From: Planning
Subject: FW: 3/2025/0970 Eight at Gazegill FAO Mr Ben Taylor

Rimington Parish Council has no objections in principle to the above applicaton, However, there are 3 issues of concern:

Drawing No; P101 - 6th Feb 26

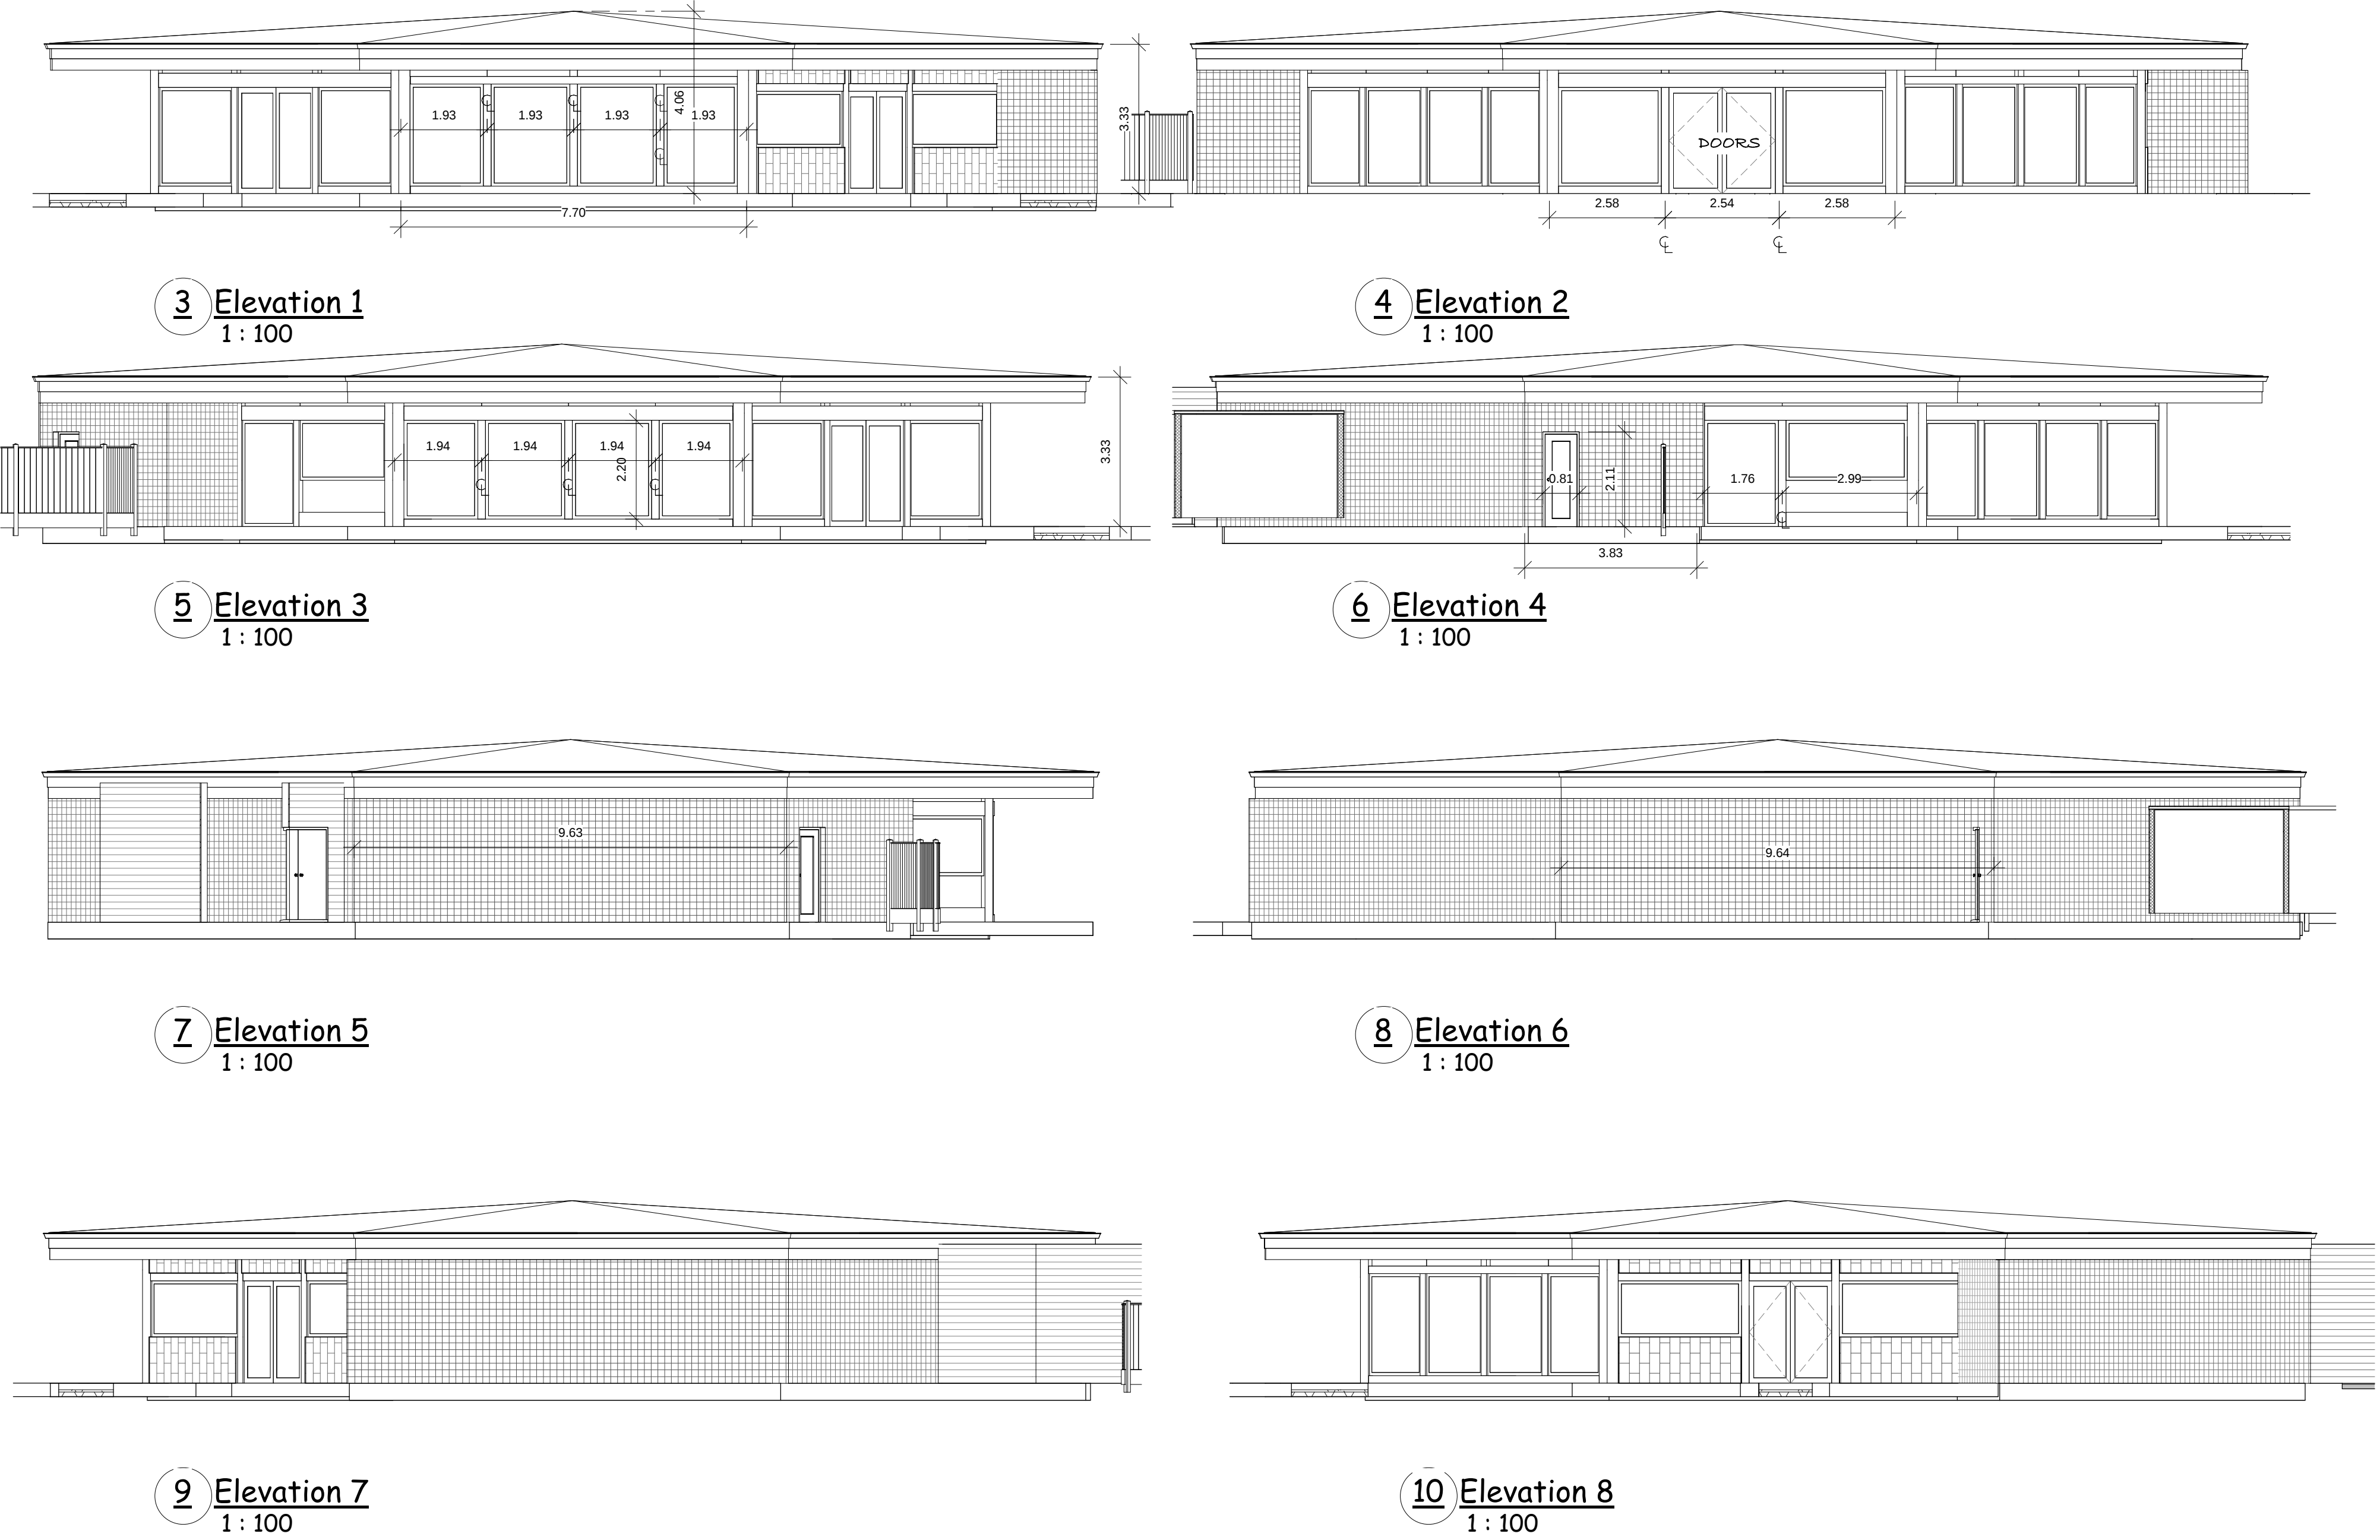
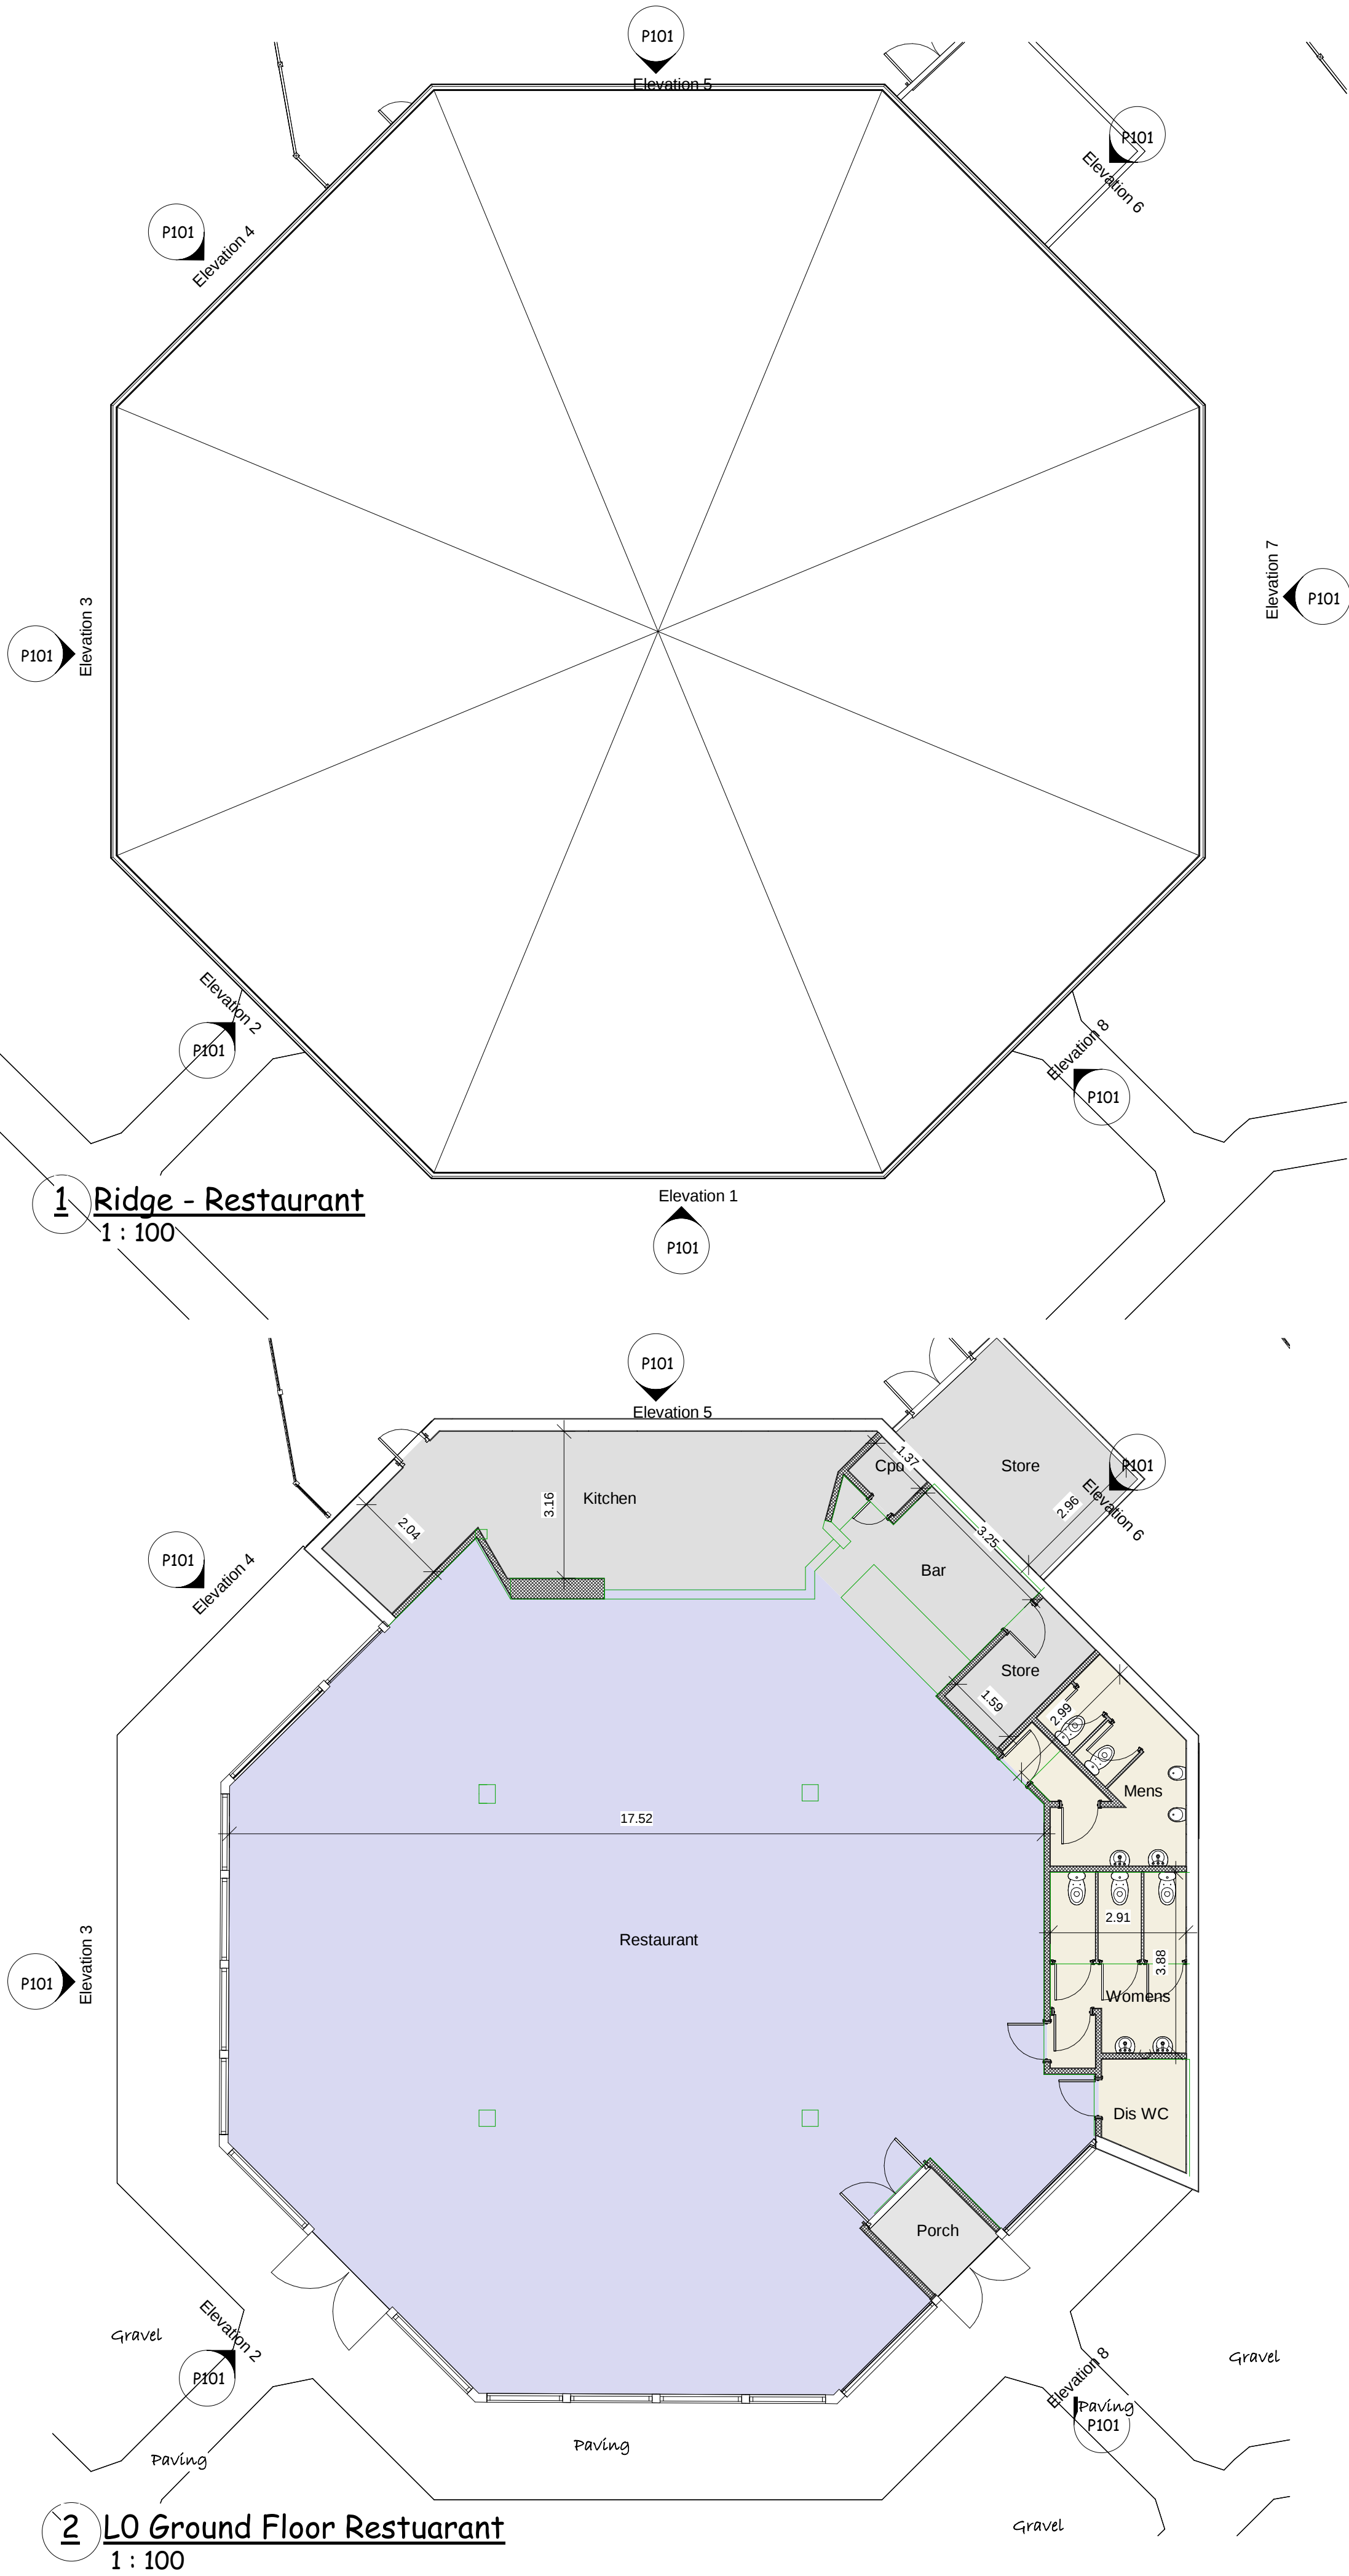
1. The opening hours stated on the application are the restaurant dining times, do they ask everyone to leave and close up at 8.30pm on Friday and Saturday nights, if they remain open longer they would be in breach of planning.
2. To satisfy access arrangements informal laybys have been provided, what do they mean by informal?
3. Previously Gazegill were advertising as a wedding venue. This will result in a higher traffic volume and will presumably lead to later hours opening. Is this no longer proposed or will they be applying for an extension for each event?
